Southampton to London Pipeline Project

Deadline 6 Submission

March 2020

CUT LINE SHEET 59 SHEET 19

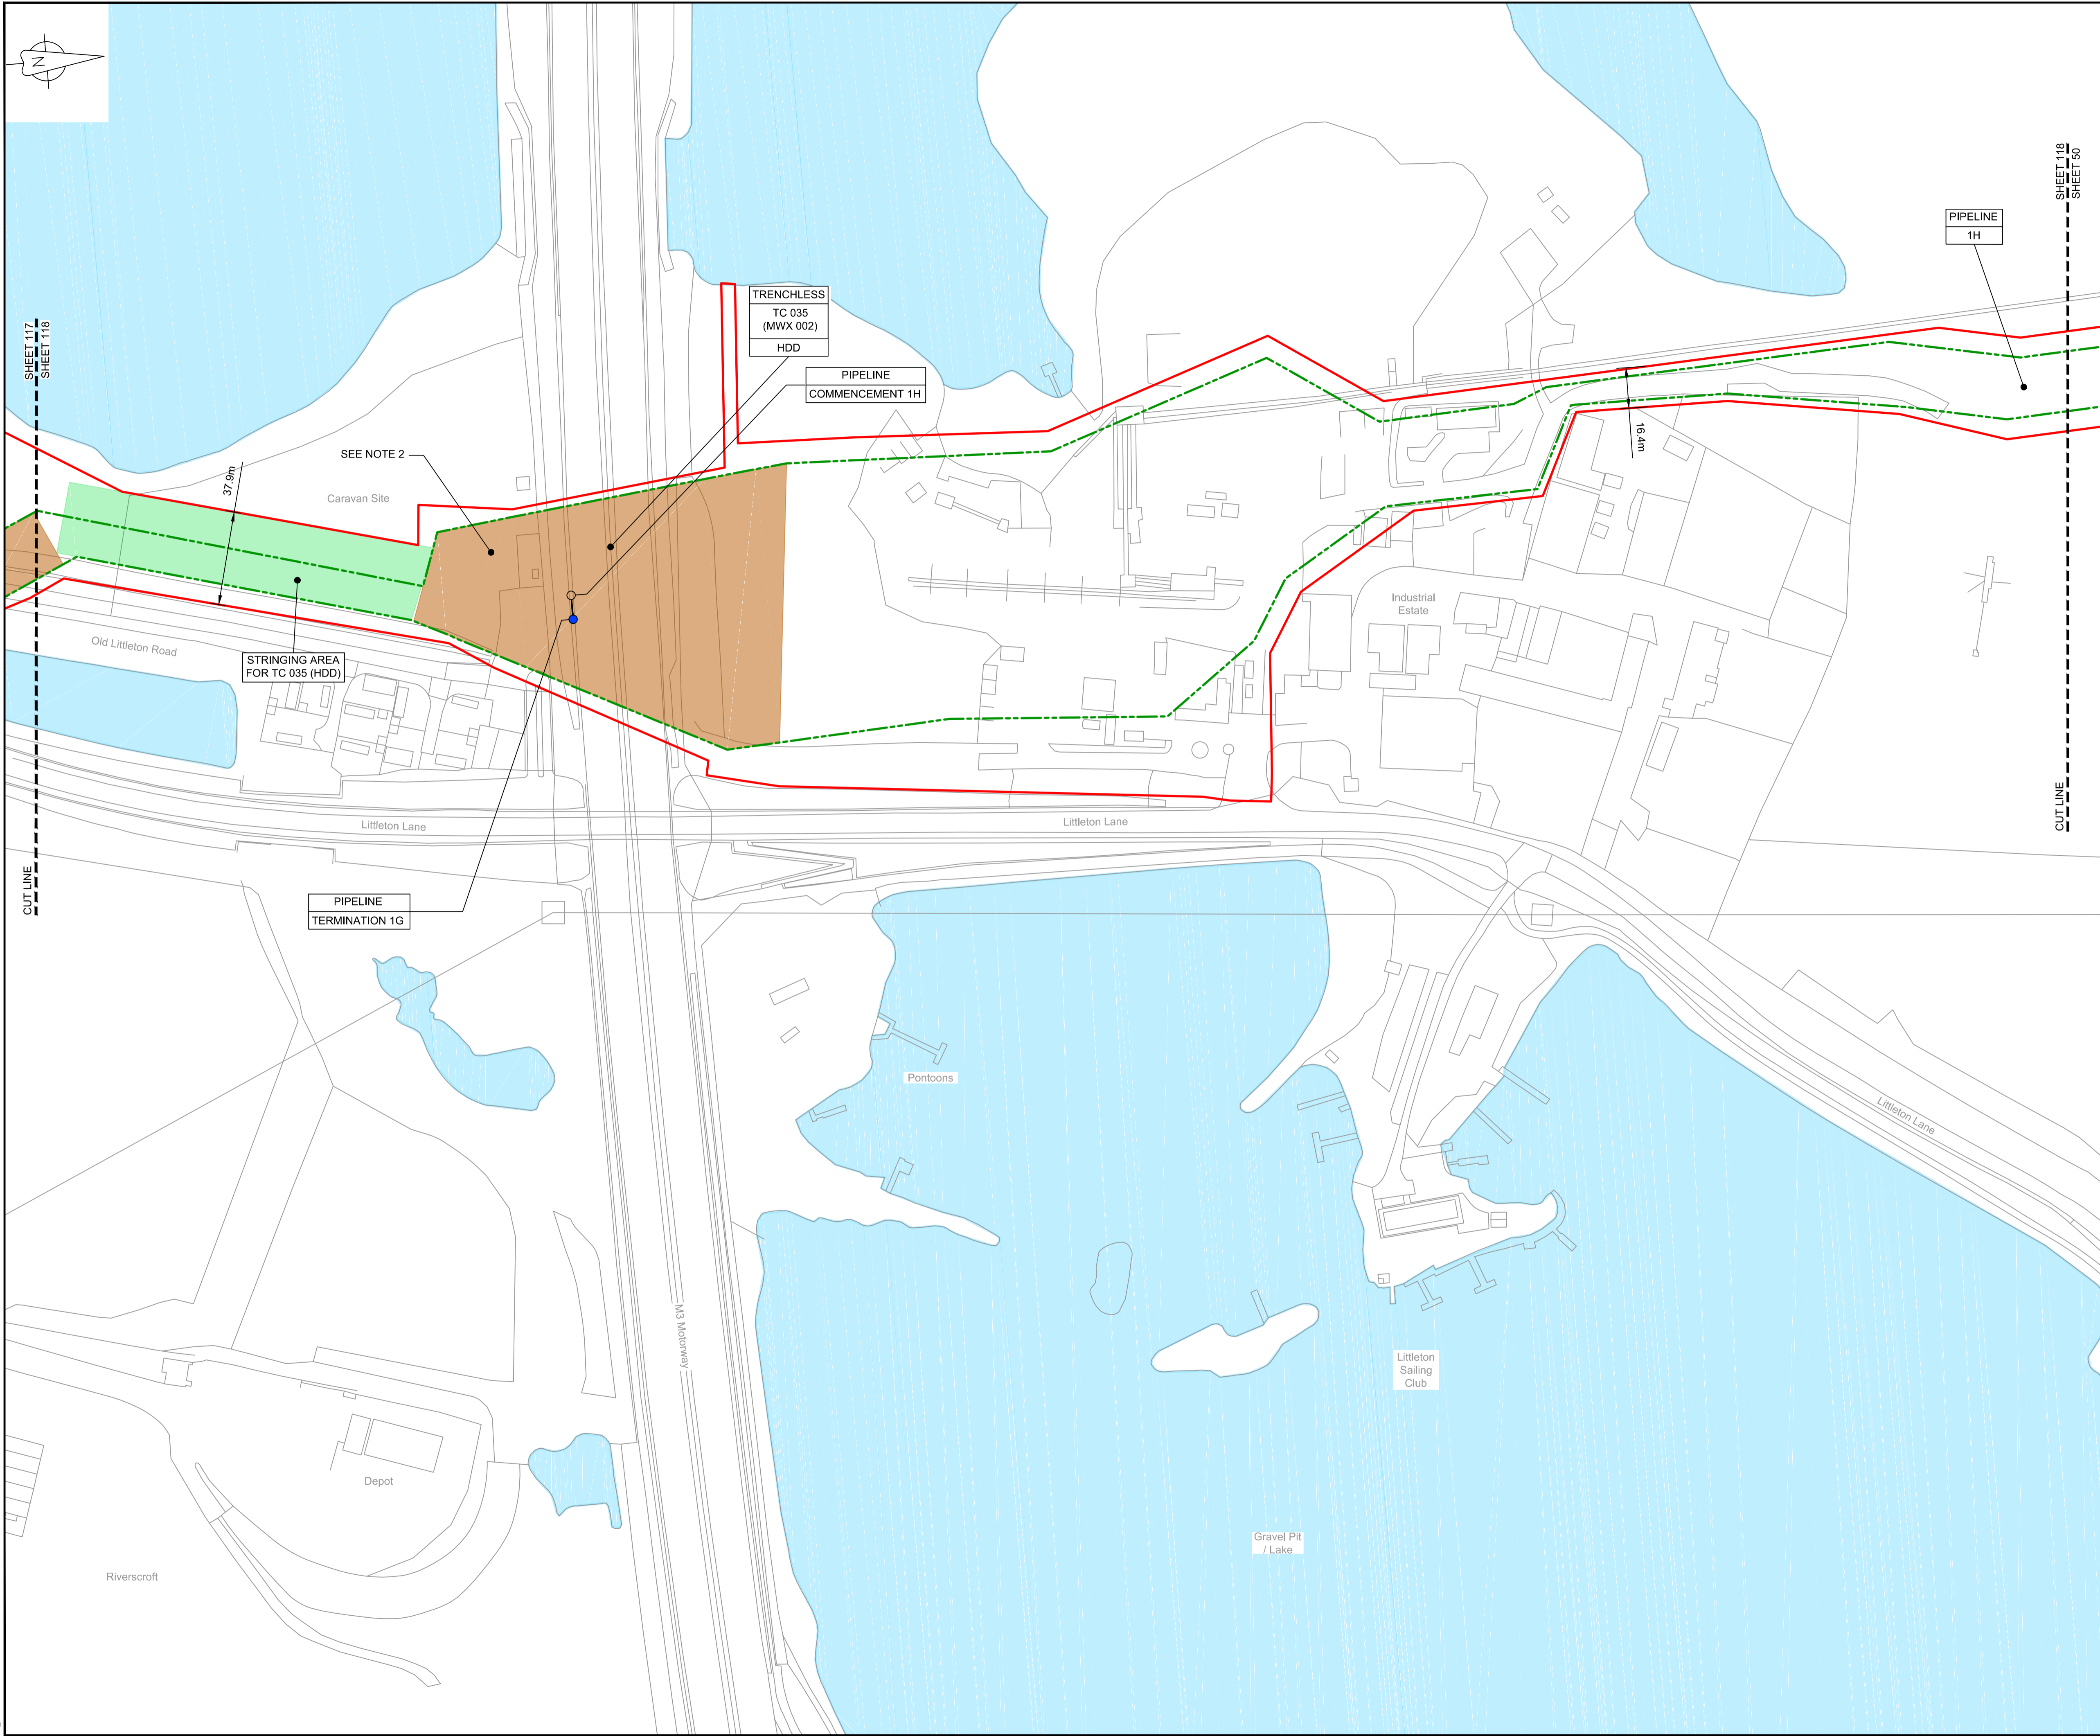
- 6.1 This submission by the applicant (Sheet 59) contains the amended plans for the the temporary logistics hub, at the A31/A32 junction in Chawton. During the examination process the applicant has significantly reduced the size of this temporary logistics hub (by around two thirds) and the applicant has now proposed to position it within a part of the site at a lower elevation. These changes reduce the visual impact on the National Park significantly (when compared to the proposal at the outset of the examination) and, with the applicant’s commitment to use British Standard BS5837 in respect of trees which will help to protect mature trees that provide screening, the Authority no longer raises any concern on this matter.
